**WELWYN HATFIELD BOROUGH COUNCIL
EXECUTIVE DIRECTOR - PLANNING, PUBLIC PROTECTION AND GOVERNANCE**

Application No: 6/2020/1989/PN8
Location: 89 Lemsford Road Hatfield AL10 0DZ
Proposal: Prior approval for the erection of a single storey rear extension measuring 6m in depth, 3.10m in height and 3m to the eaves.
Officer: Mr Tom Gabriel

Recommendation: Prior Approval Refused

Drawing	PROPOSED SITE PLAN		
Job	89 Lemsford Road, Hatfield, AL10 0DZ		
Job No.	Date	Drm	Chk
2020/066	12/08/2020	A.S.	G.E.
Scale	Drawing No.	Revision	
1:500	066/PR/202

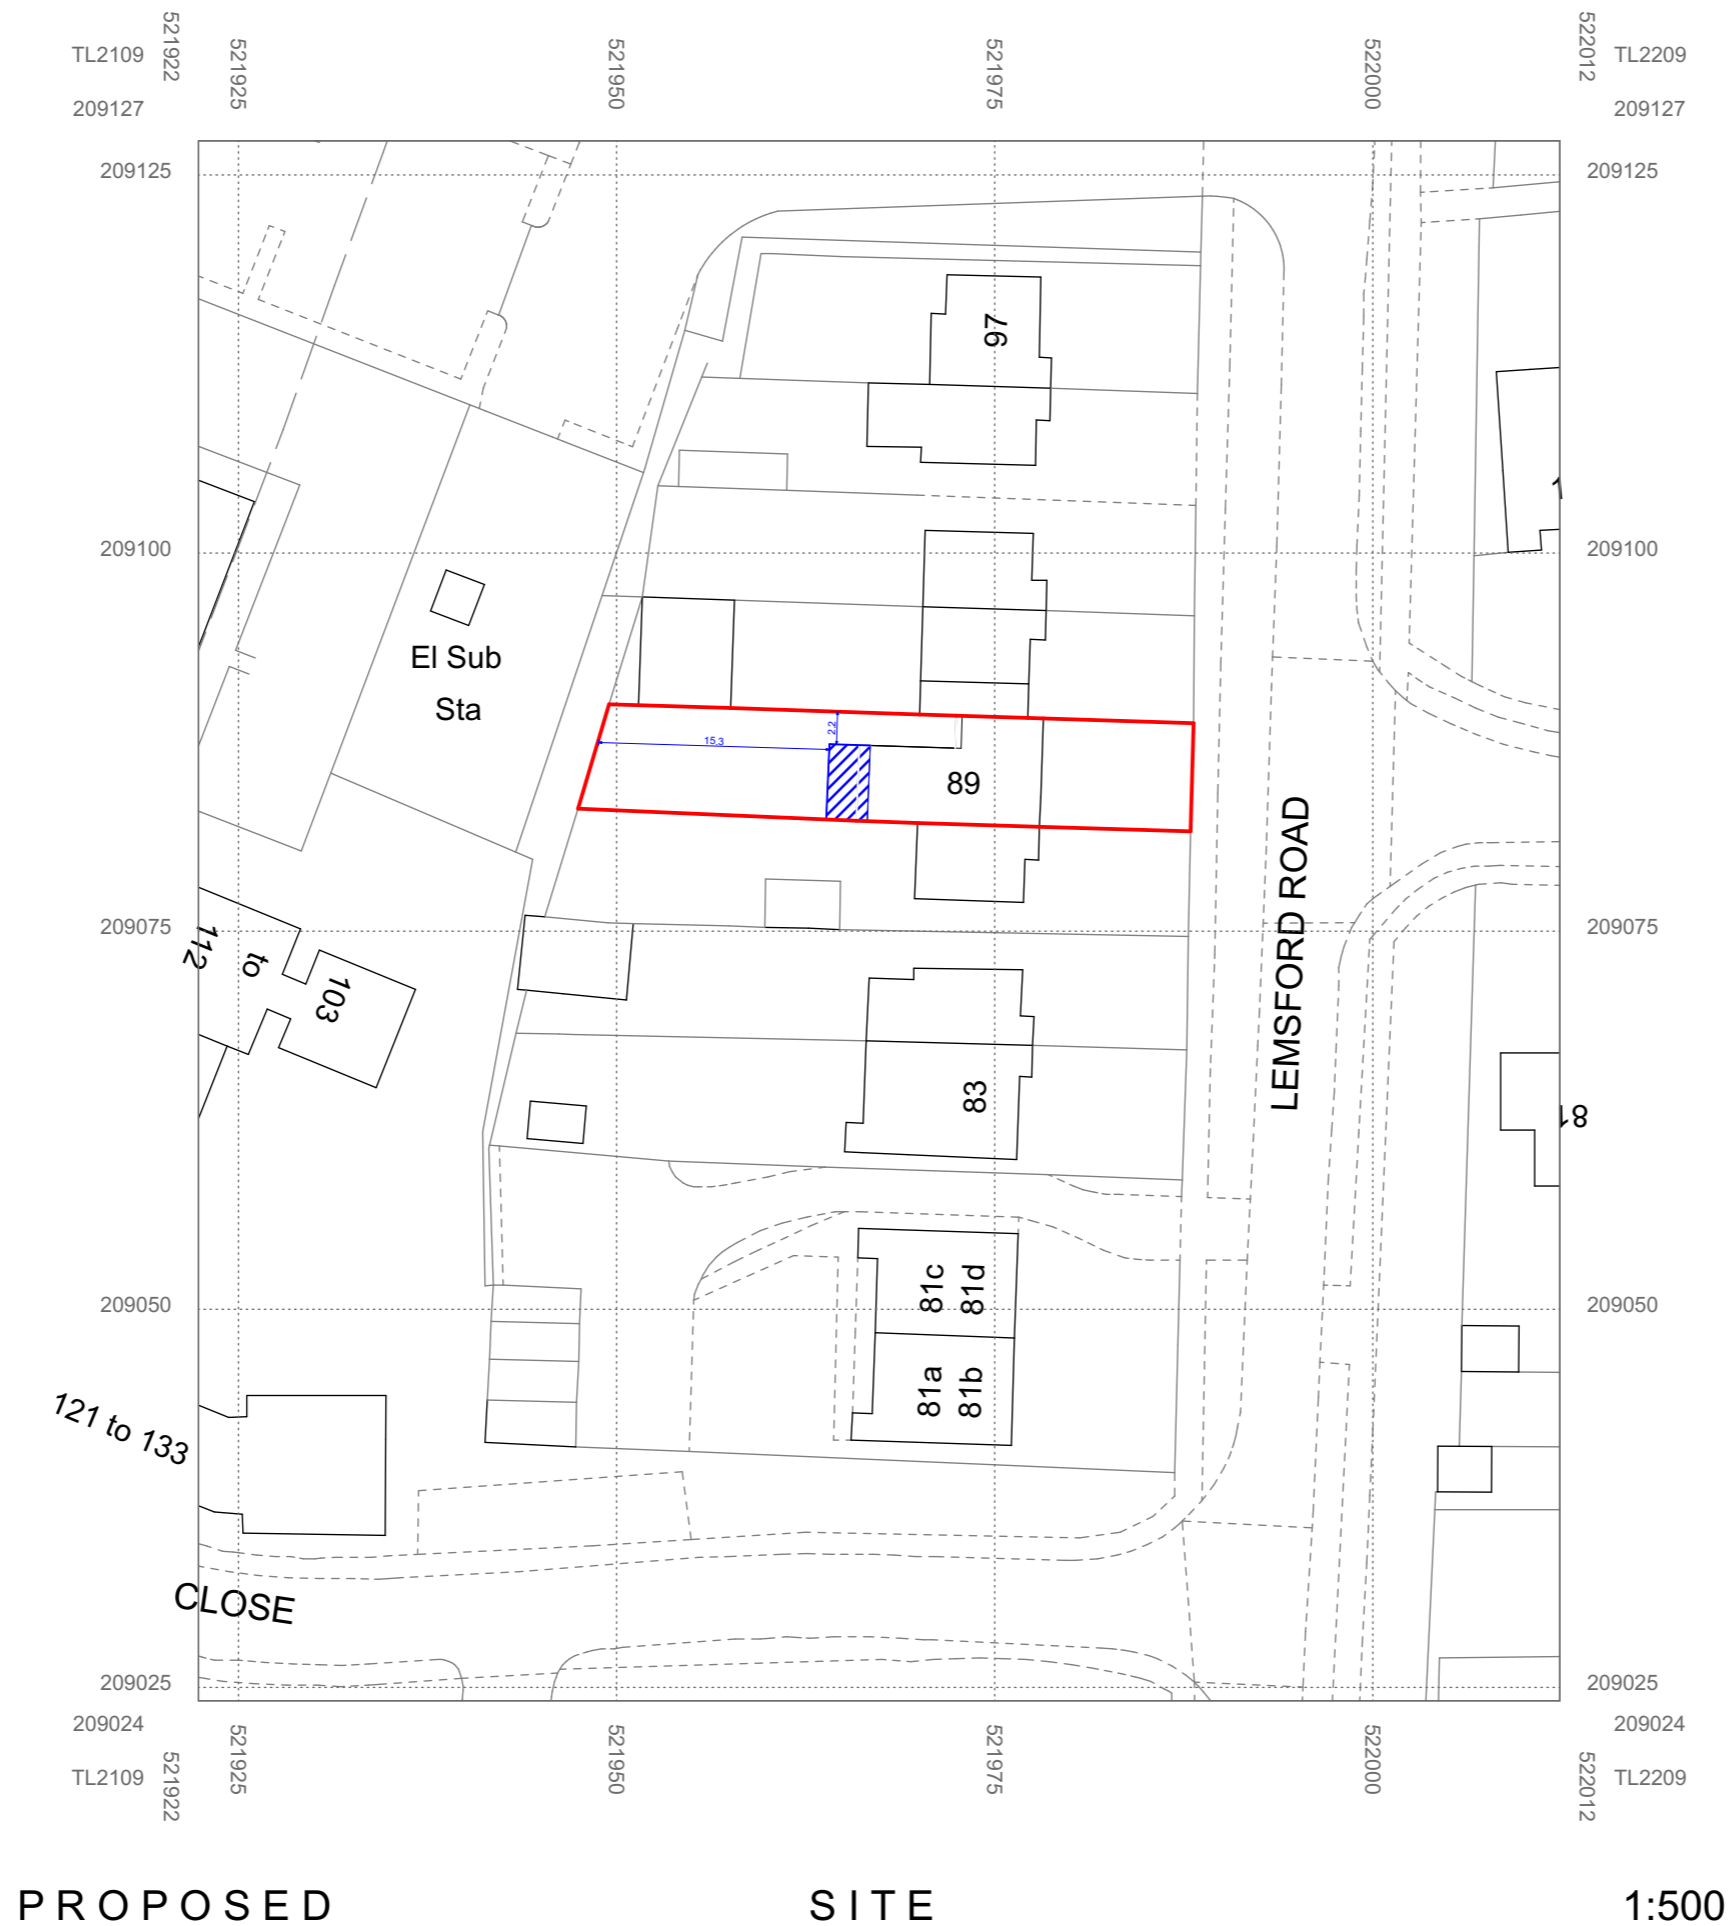
The forms submitted with the application state that the eaves height of the extension would be 3m though the extension would be 3.1m high in total. The extension would have a flat roof. The Permitted Development Rights for Householders Technical Guidance states 'Eaves height is measured from the ground level at the base of the outside wall to the point where that wall would meet the upper surface of the flat roof' (p.12). Accordingly, the proposed extension would be within 2m of the boundary of the curtilage of the dwellinghouse and would and the height of the eaves of the enlarged part would exceed 3m. It therefore does not comply with Class A 1 (h) (i) of Part 1, Schedule 2 of the Town and Country Planning (General Permitted Development) (England) Order 2015.

Moreover, the proposed materials of construction have not been specified either on the plans for the proposal or the application forms. The proposal therefore does not comply with Paragraph A 3 (a) of Class A of Part 1, Schedule 2 of the Town and Country Planning (General Permitted Development) (England) Order 2015.

1. The proposed extension would be within 2m of the boundary of the curtilage of the dwellinghouse and would and the height of the eaves of the enlarged part would exceed 3m. It therefore does not comply with Class A 1 (h) (i) of Part 1, Schedule 2 of the Town and Country Planning (General Permitted Development) (England) Order 2015.
2. The proposed materials of construction have not been specified either on the plans for the proposal or the application forms. The proposal therefore does not comply with Paragraph A 3 (a) of Class A of Part 1, Schedule 2 of the Town and Country Planning (General Permitted Development) (England) Order 2015.
